Lime Down

Solar Park

Statement of Common Ground with Dorset and Wiltshire Fire and Rescue Service (Clean)

Document Reference: EXAM/8.13

Title: Figure 3-3: 400kV Substation and BESS Layout

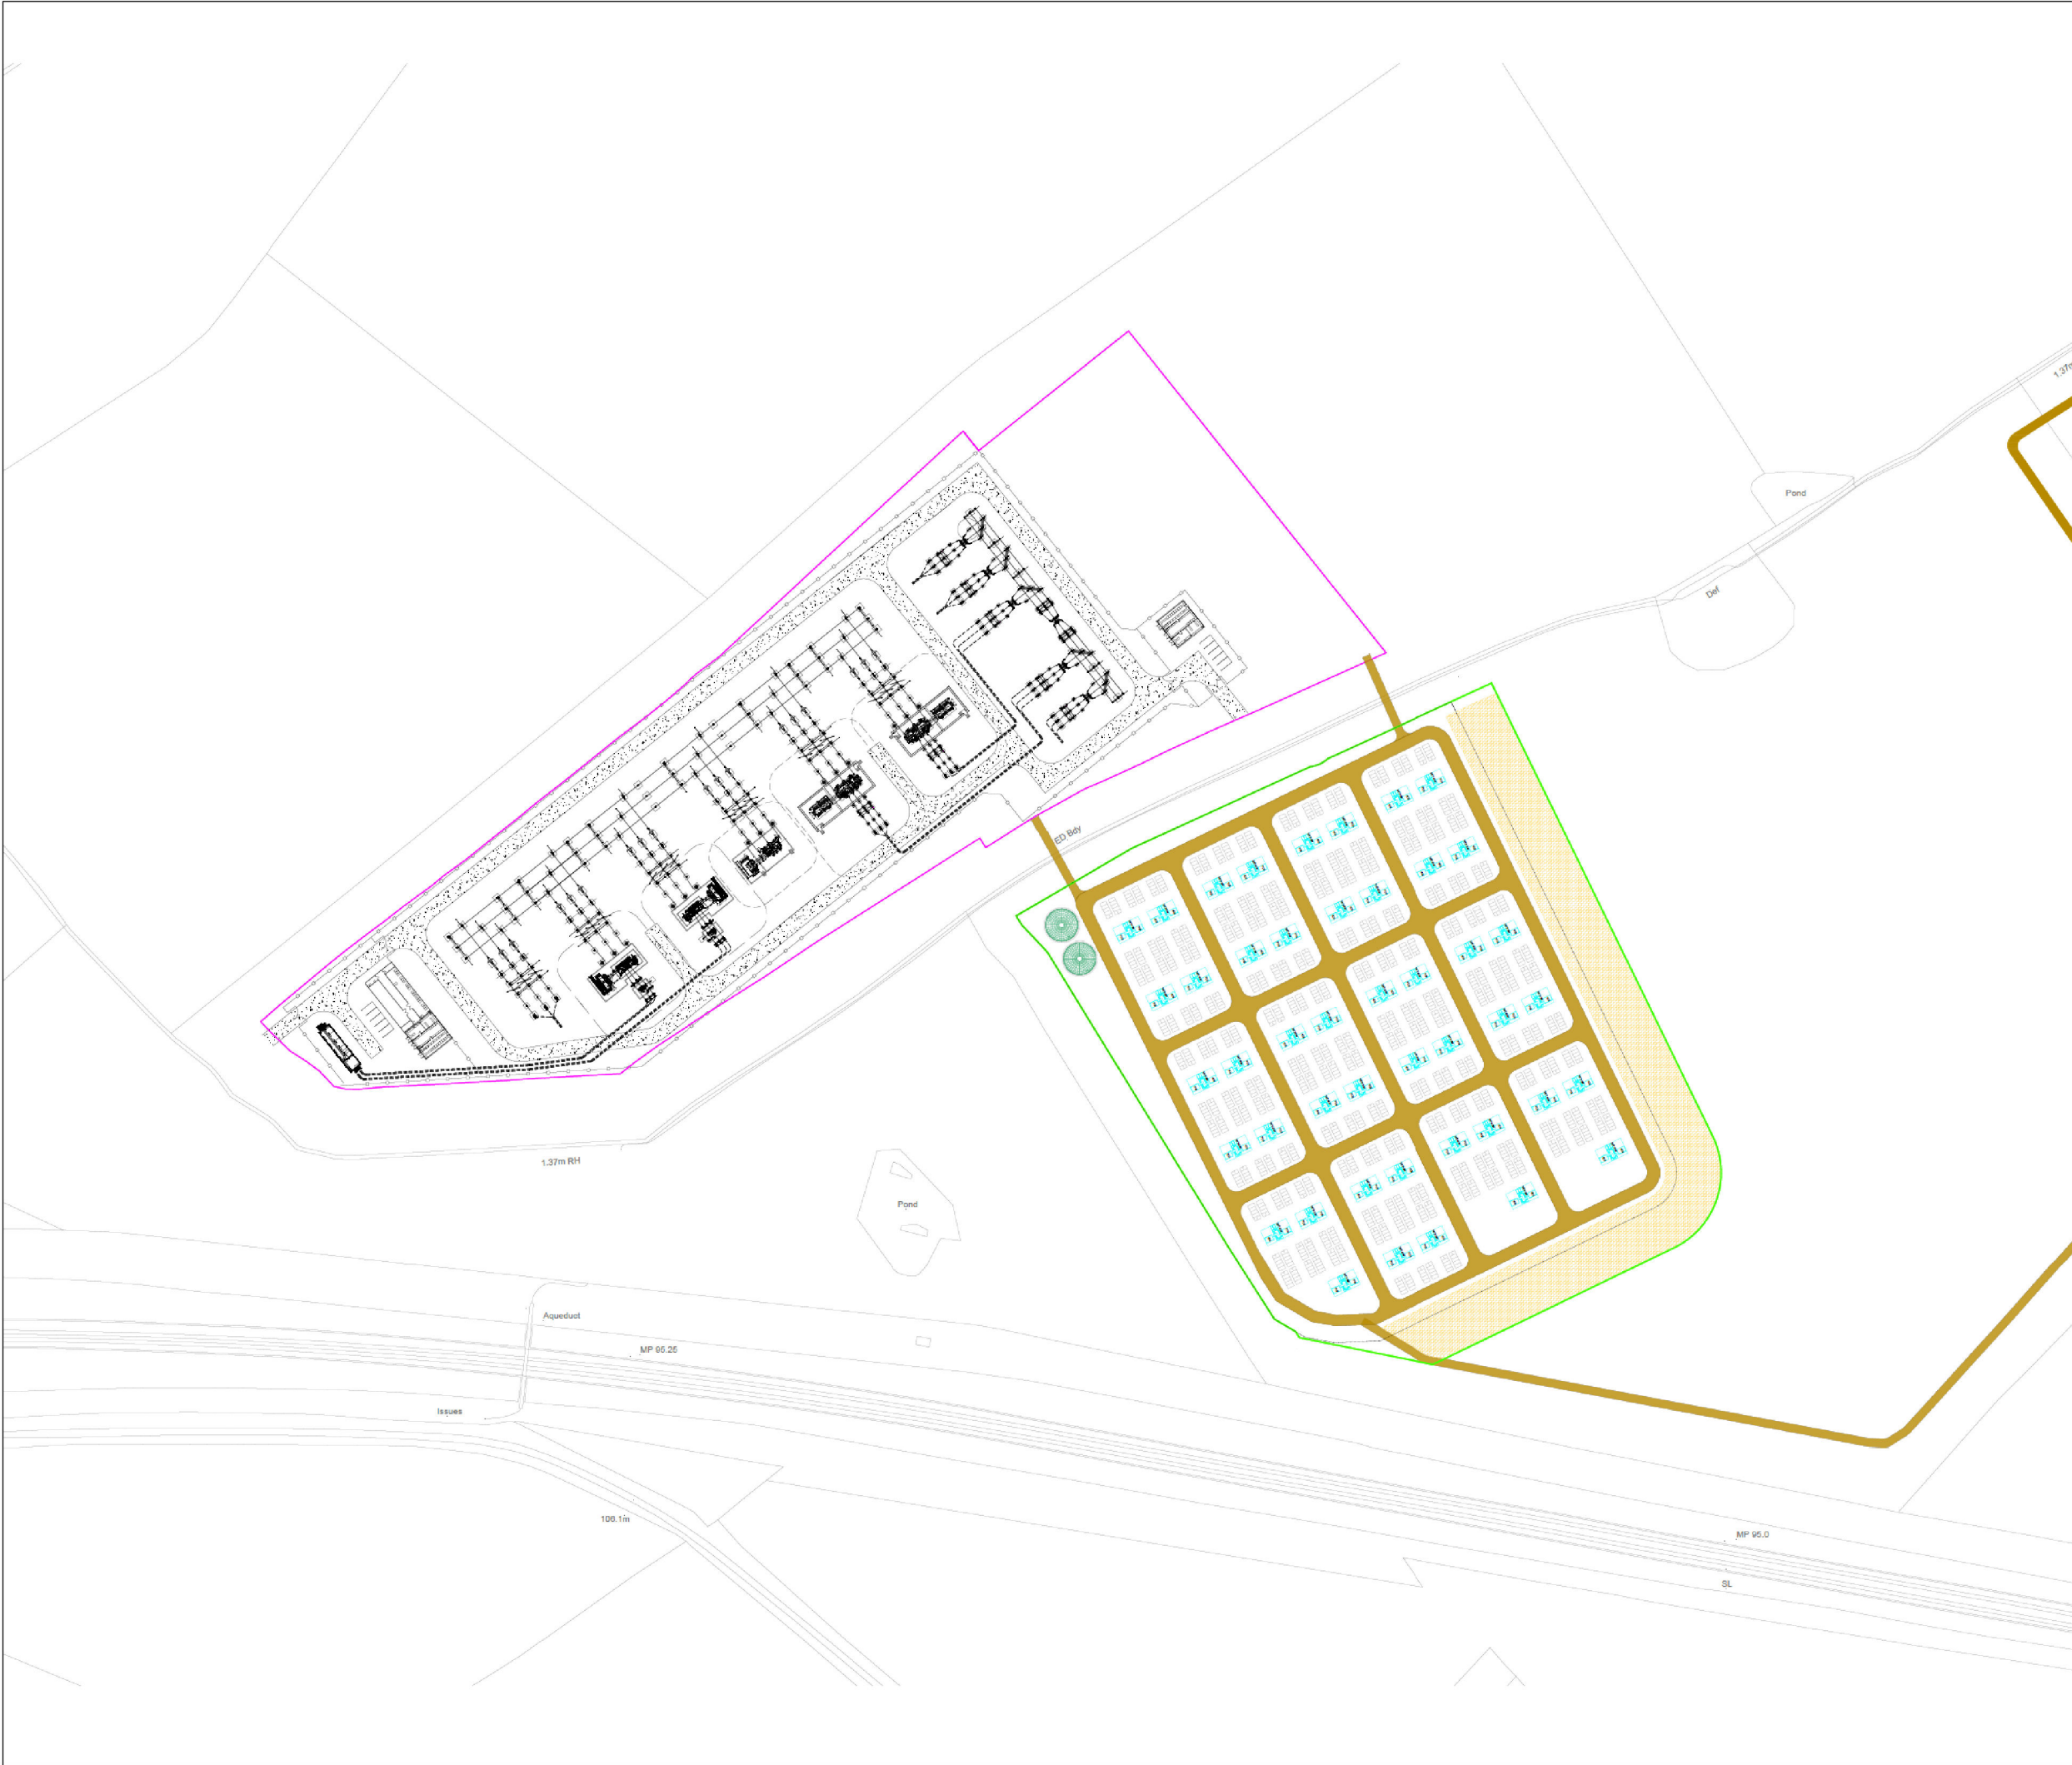
Reference	Sub-topic	Dorset & Wiltshire Fire and Rescue Service Position	Applicants Position	Status
		appliances is considered beneficial. Hydrant supply from a pumped/ pressure fed system with appropriate outlets within 90m of BESS containers has been confirmed. The applicant has confirmed compliance with UL9540A and NFPA855 in respect of separation between BESS containers, including live fire testing and the use of fire-resistant materials and deflagration ventilation to prevent the lateral spread of fire. The Emergency Response Plan (ERP) should be developed on the basis that fire will not spread to an adjacent container, this will be supported by appropriate test evidence. Fire and Rescue operations should therefore be limited to monitoring the BESS involved and cooling adjacent exposures. Updated Position	boundary cooling intervention from firefighters. The Applicant will also commission site specific heat flux and flame tilt consequence modelling to account for site topography and wind conditions to establish final equipment spacing distances for the Scheme. Further detail on safe BESS design commitments can be found in the Outline BSMP [REP3-106], Section 4.1. Further detail on BESS detection and suppression system commitments can be found in the Outline BSMP [REP3-106], Paragraphs 4.1.30 to 4.1.33. Further detail on safe BESS explosion prevention and protection commitments can be found in the Outline BSMP [REP3-106], Section 4.1.34. The Applicant confirms that in line with NFCC and NFPA 855 guidance that in

3.2.6	Design of access roads for firefighting	NFCC Grid Battery Energy Storage Systems Planning – Guidance for FRS Version 1 indicated that two separate access routes should be provided to allow for emergency access in varying	The Applicant has worked with D&WFRS to ensure that emergency access routes are appropriate for D&WFRS appliances to operate in all weather conditions. Access roads will	Agreed

Reference	Sub-topic	Dorset & Wiltshire Fire and Rescue Service Position	Applicants Position	Status
	appliances and emergencies.	wind conditions. Version 2 of the above guidance allows for additional flexibility where perimeter access within the site offers tactical options to manoeuvre within the site. Internal tracks and access roads have been assessed for width, load bearing capability and swept path analysis carried out in compliance with requirements. Updated Position Dorset & Wiltshire Fire and Rescue Service is content for the matter to be updated from "Under Discussion" to "Agreed" on the basis that the commitments and obligations set out are fulfilled through the submission and agreement of the relevant follow-up documentation.	be maintained to ensure vegetation does not impede vehicle access. The Applicant confirms road networks within the Order Limits will enable unobstructed access to all areas of the BESS sites. Two separate access routes servicing three separate D&WFRS access points to the BESS site have been integrated to ensure firefighters do not have to drive through a smoke or gas plume to access the BESS. The proposed access-route width around the BESS area will be 6 m and there are no dead-end access routes or extremes of grade. Further detail on Fire Service Access can be found in the Outline BSMP [REP3-106], Section 5.4.
